**From:** [Holly Erdman](#)  
**To:** [Kelly Bacon \(CD\)](#)  
**Subject:** RE: Notice of Application BL-19-00021 Lazy Ed Ranch  
**Date:** Thursday, October 24, 2019 2:33:55 PM  
**Attachments:** [image001.png](#)

**From:** Kelly Bacon (CD)  
**Sent:** Monday, October 14, 2019 9:50 AM  
**To:** Jesse Cox; Holly Erdman; Candie Leader; Gail Weyand; Pat Nicholson  
**Cc:** Lindsey Ozbolt  
**Subject:** Notice of Application BL-19-00021 Lazy Ed Ranch

Please review the following Boundary Line Adjustment application submitted by John Downey for Lazy Ed Ranch (BL-19-00020). Any Comments need to be submitted by 5pm on October 29, 2019. Please let me know if there are any questions.

# LAZY ED RANCH SITE PLAN

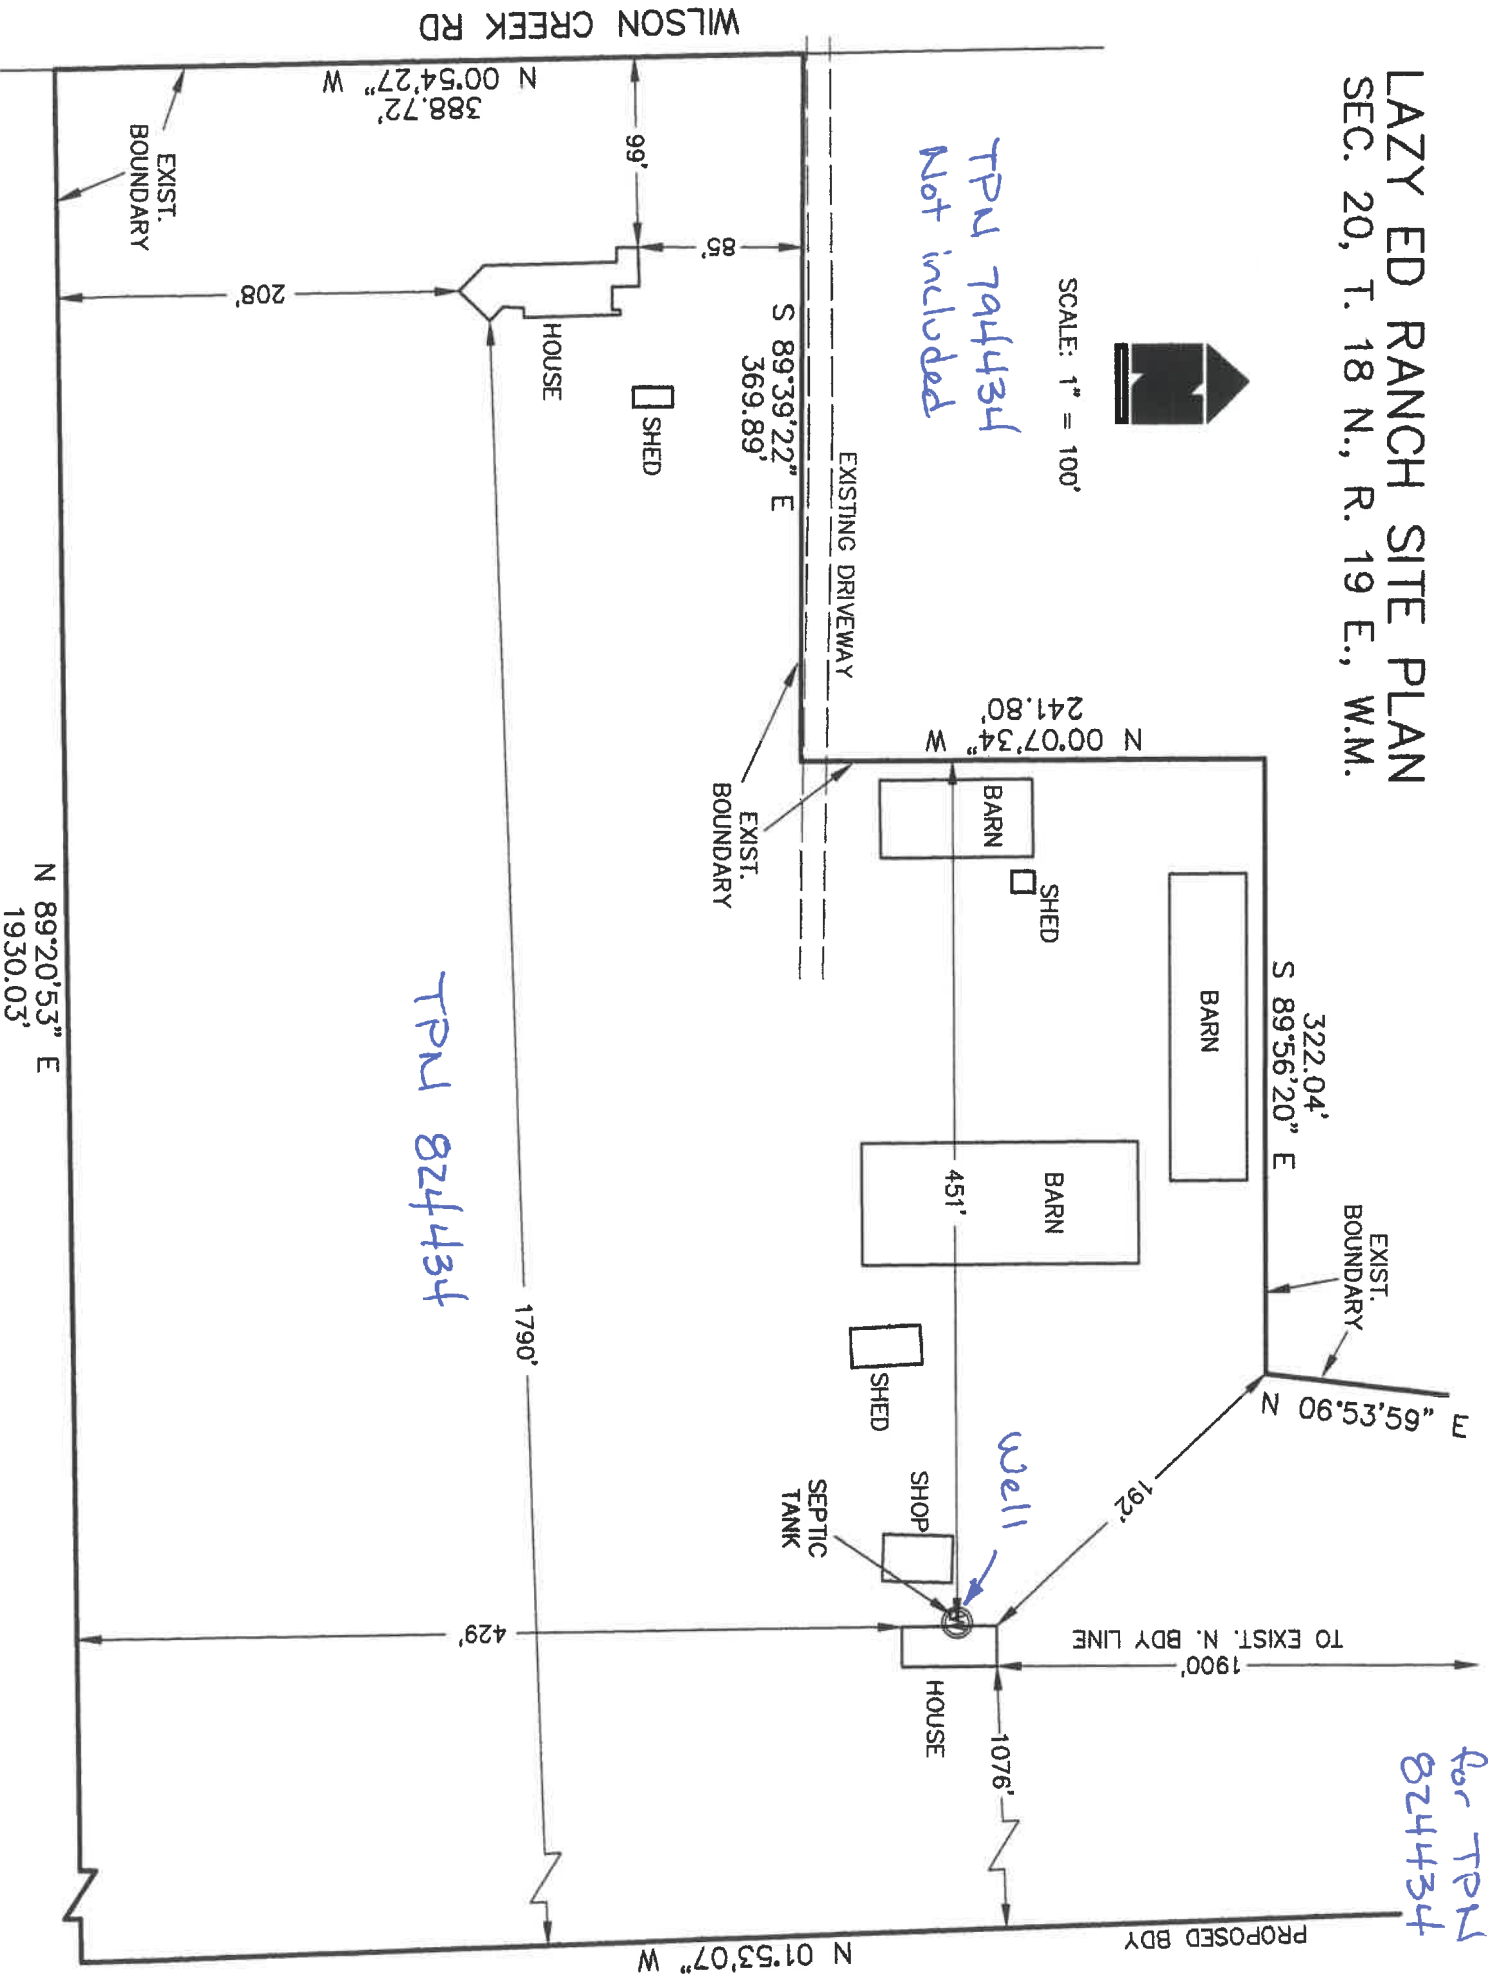
I went to review this and discovered that the drawing that is considered the existing site plan points to the "w" with the circle around it as the well and it is also labelled as the septic tank. I need some clarification on where the septic tank and the drainfield are located before I can sign off for environmental health.
